Our ref: WA/2021/129266/04-L03
LPA ref: 21/02286/F

Construction of a coffee unit with drive-thru facility and indoor seating with associated access, car parking, landscaping and servicing parking

Land north west of Launton Road roundabout adjoining Skimmingdish Lane, Caversfield

The FRA reference 680020-R1(02)-FRA dated July 2022 does not satisfactorily address our earlier concerns. We therefore **maintain our objection** to this application.

Title FLOOD VOLUMES SECTIONS 2 OF 3 Original drawing sheet is A1

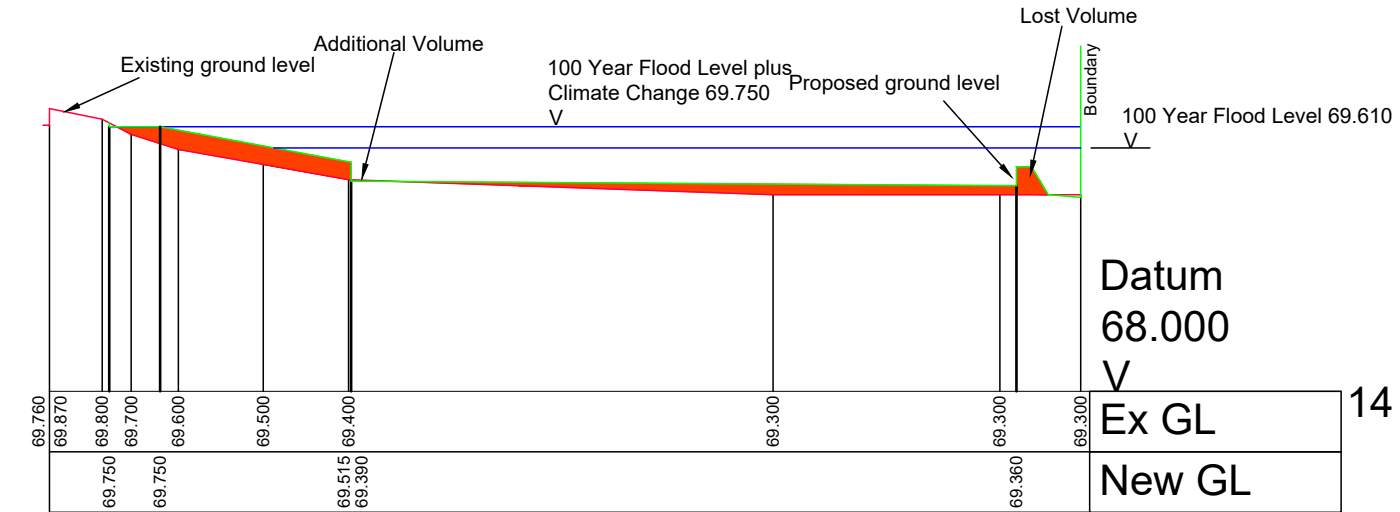
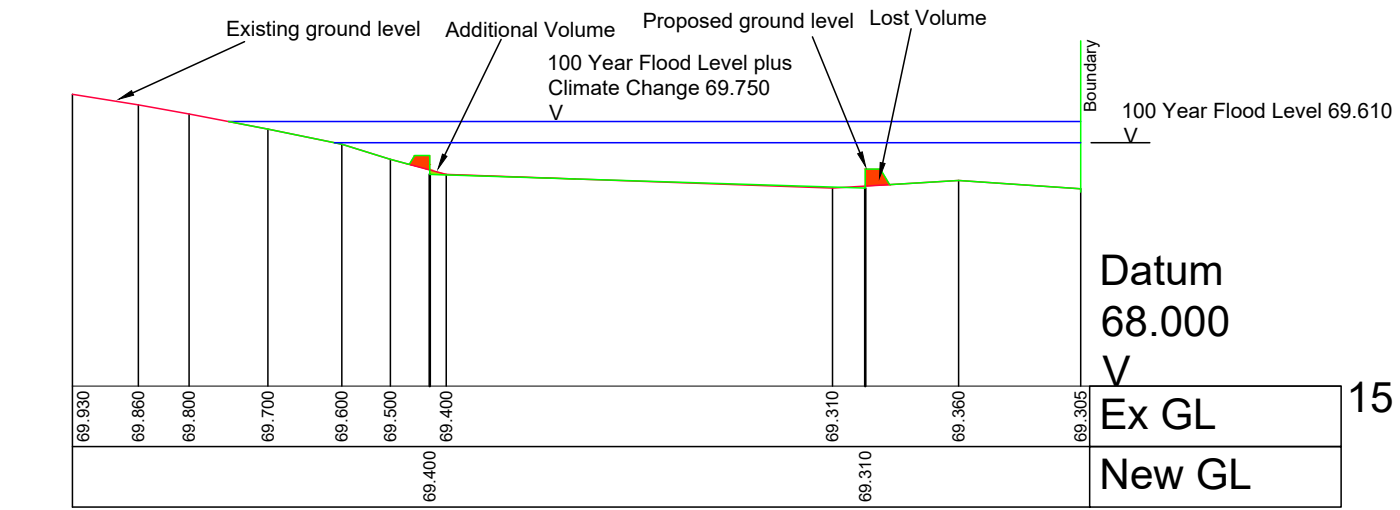
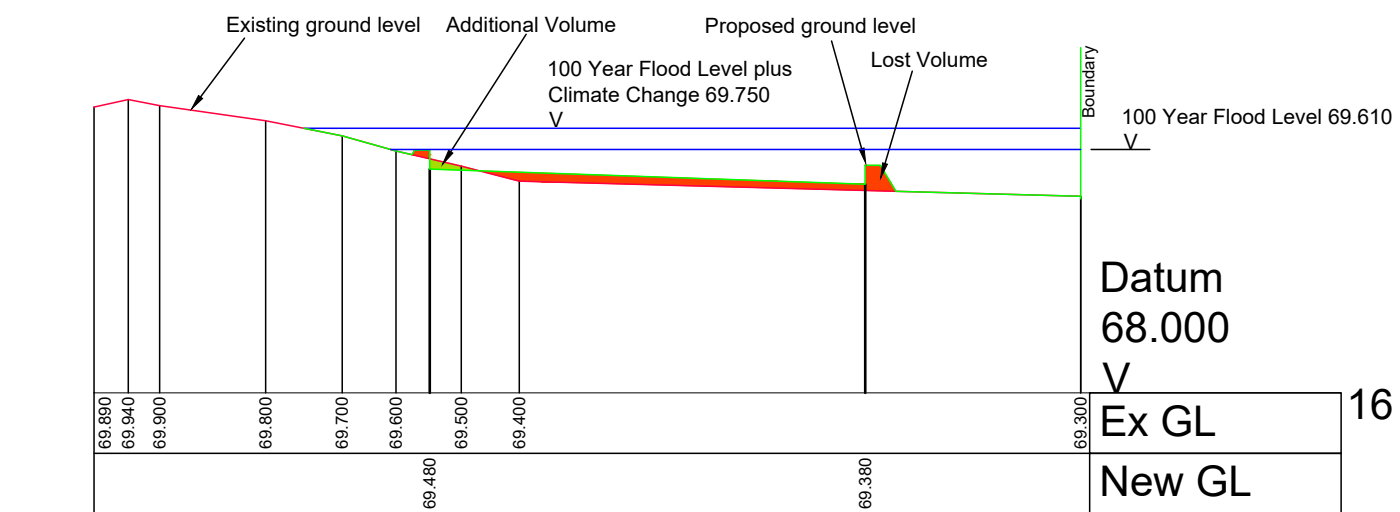
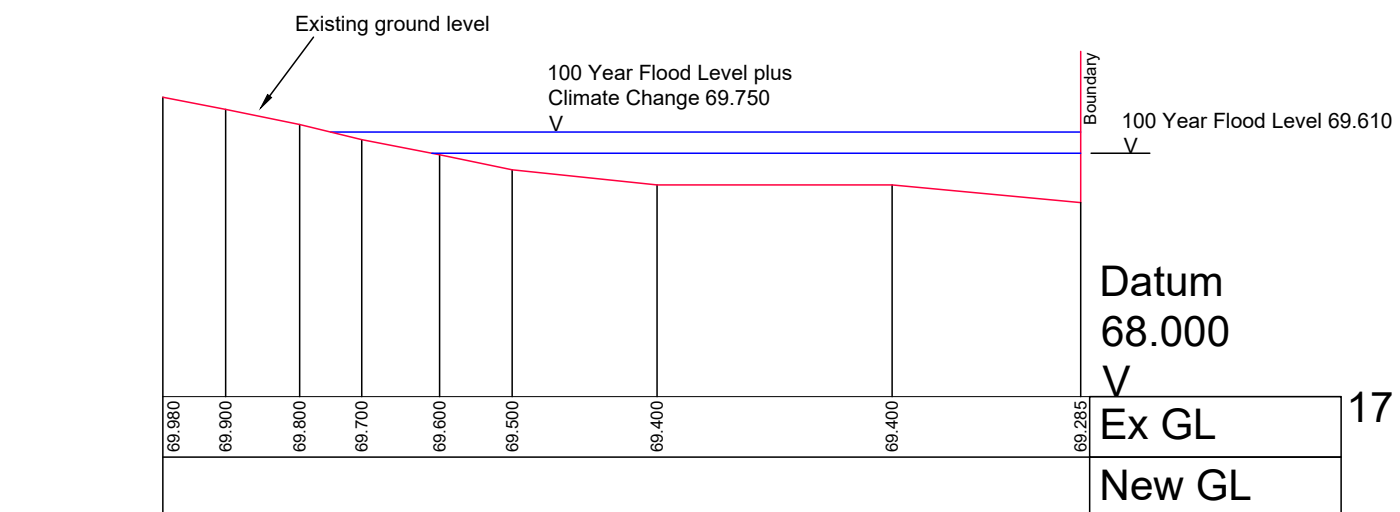
It is still difficult to understand if the scheme would be hydraulically connected. For example, from comparing the spreadsheet values and the Layout Plan, it appears that the 2.88m³ of proposed volume between 69.16-69.26mAOD on the main development site would not be accessed until a flood level of approximately 69.30-69.33mAOD is reached. No commentary on this has been provided, but it appears that sufficient compensation is provided for this lowest slice (69.16-69.26mAOD) by lowering areas of raised land outside the main development site as shown on the Flood Volumes Section Layout Plan. We request that further clarity is provided on this and how the compensation is hydraulically linked at other levels/slices.

This can be shown by including plan/s which clearly mark the extents of each compensation slice so we can visually see how they are hydraulically connected. These extents should be based on the exact areas the applicant is lowering for each slice. It is not possible to view the individual compensation slices in the applicant's submitted plans.
